# DEVIATION REVIEW AND DECISION FORM

Subdivision or Project Name: Waterview  
East Preliminary Plan

Section of ECM from Which Deviation is Sought: Appendix I Section I.7.1.B  
Specific Criteria from Which a Deviation is Sought: 1st Bullet; Providing Water Quality for Entire Development

Figure 4: Proposed Drainage Map

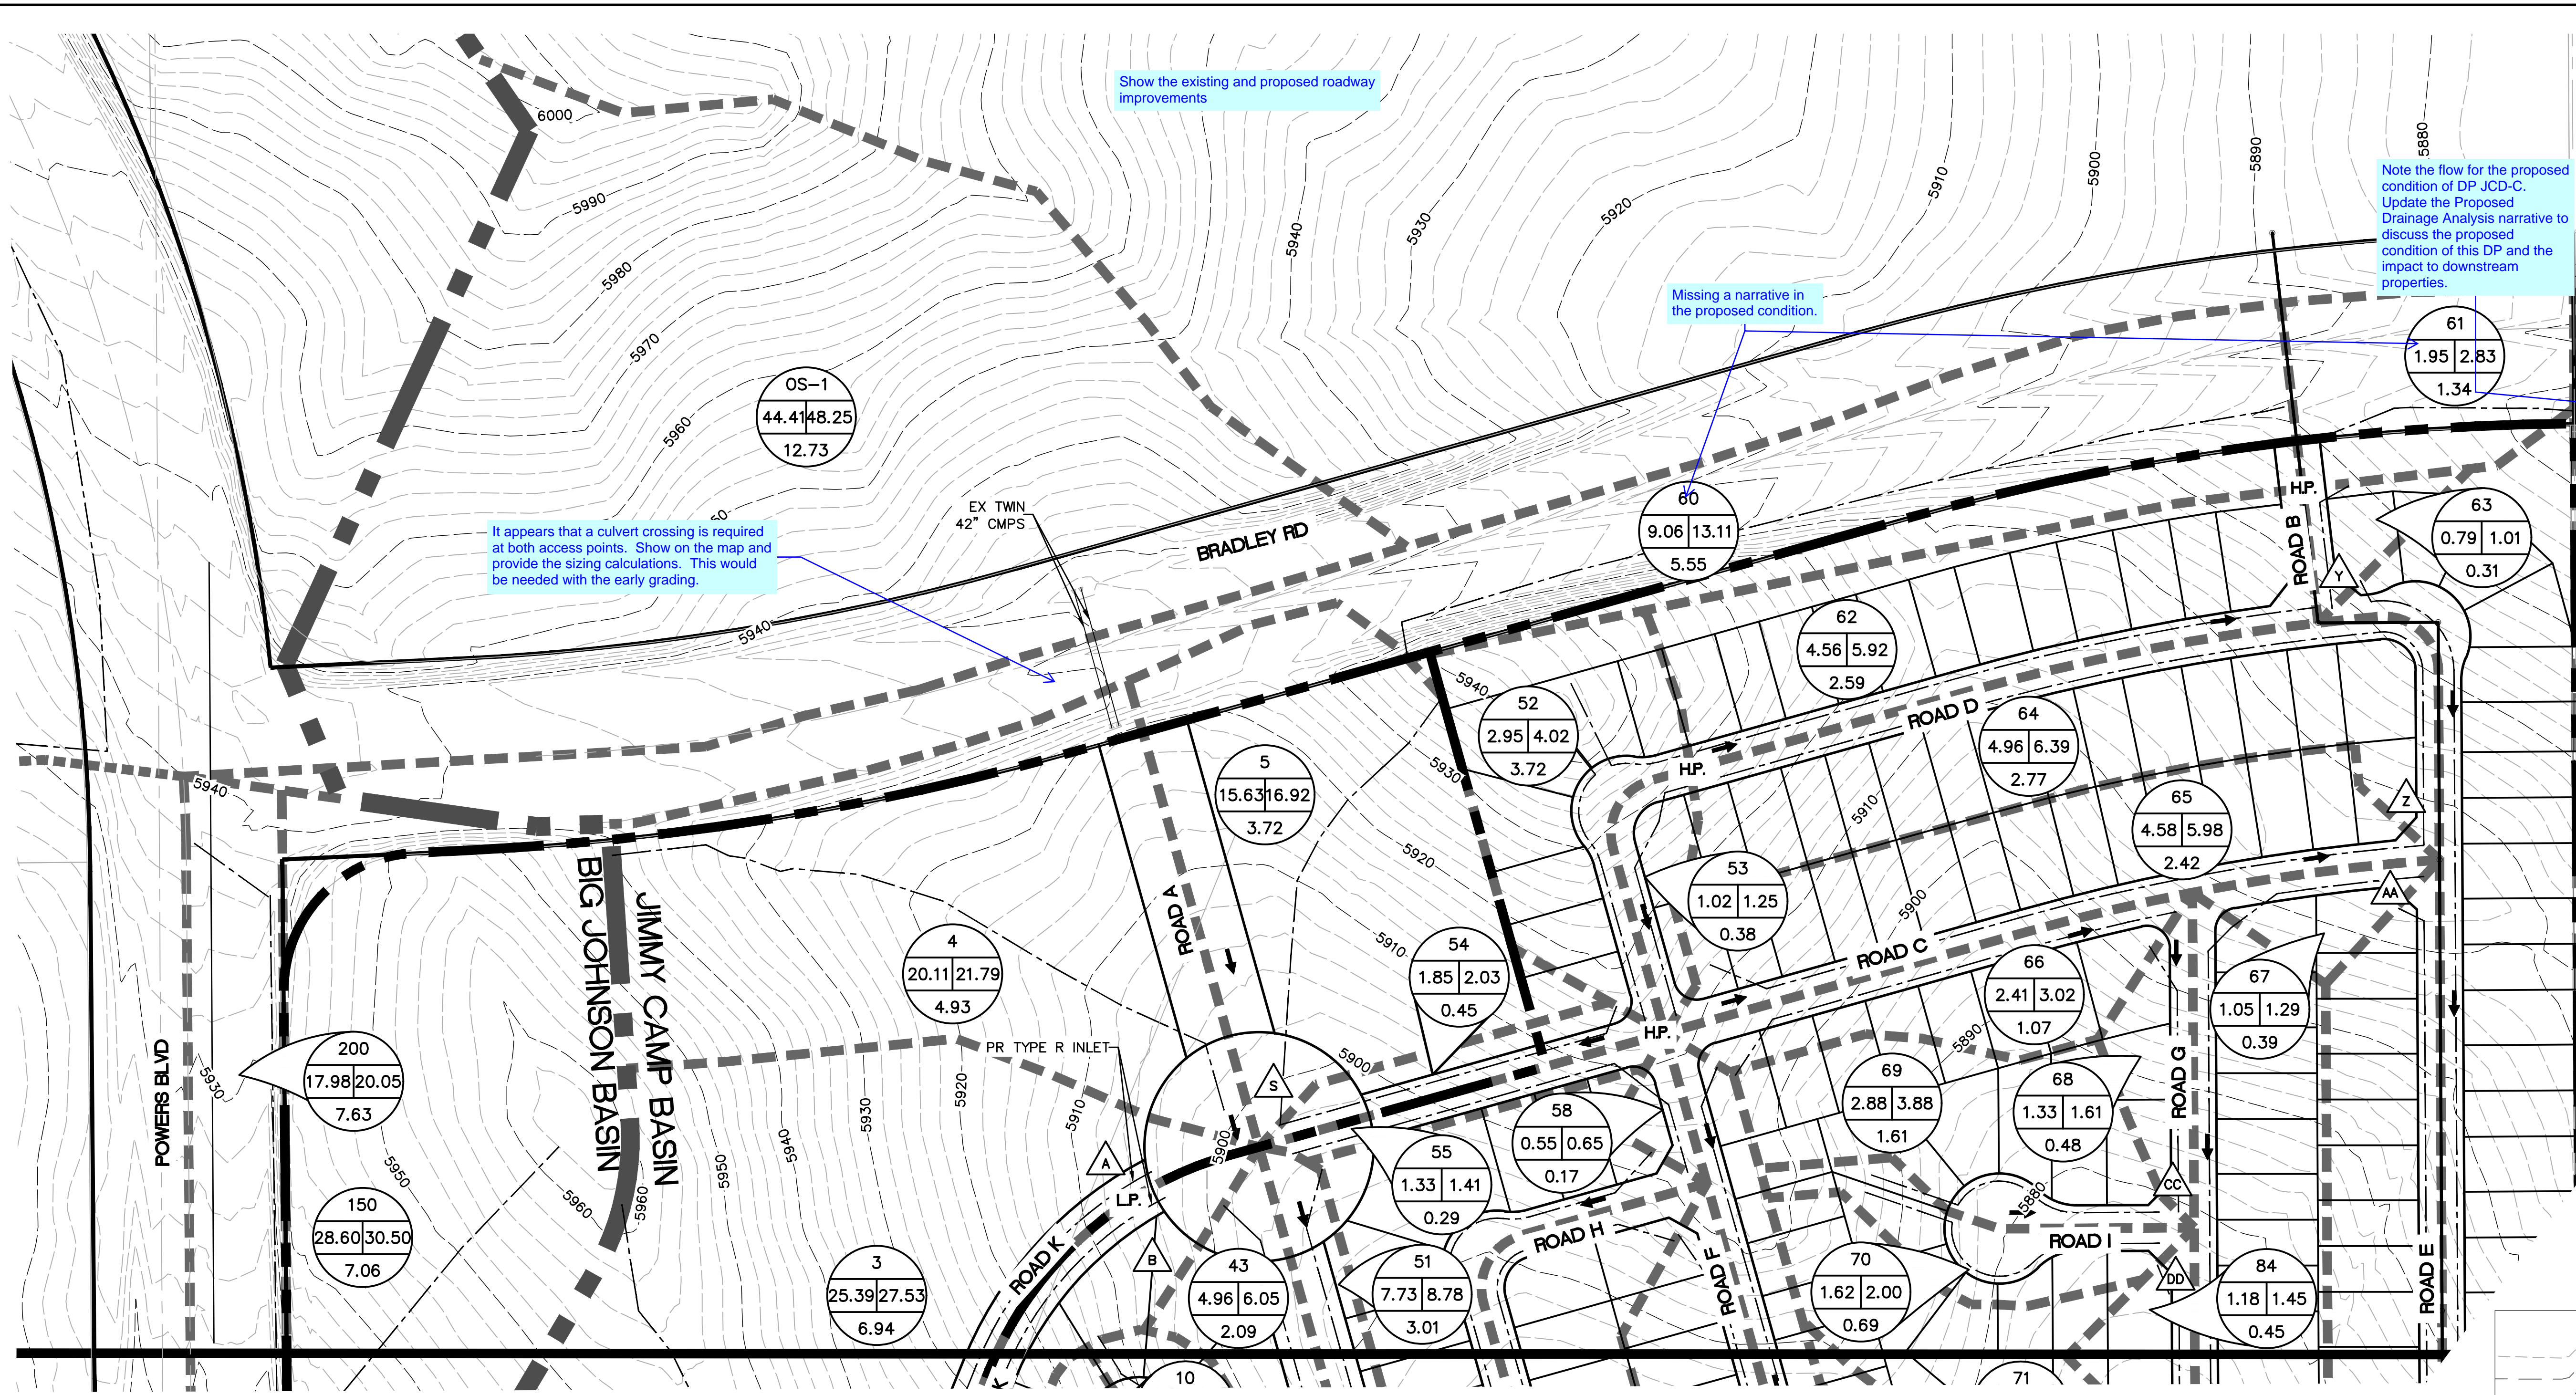
Per the narrative, it notes that 6 ac does not get treated by water quality. Update the narrative to identify which sub-basins these are.

Include an exhibit which identifies the areas not draining into a WQ detention.
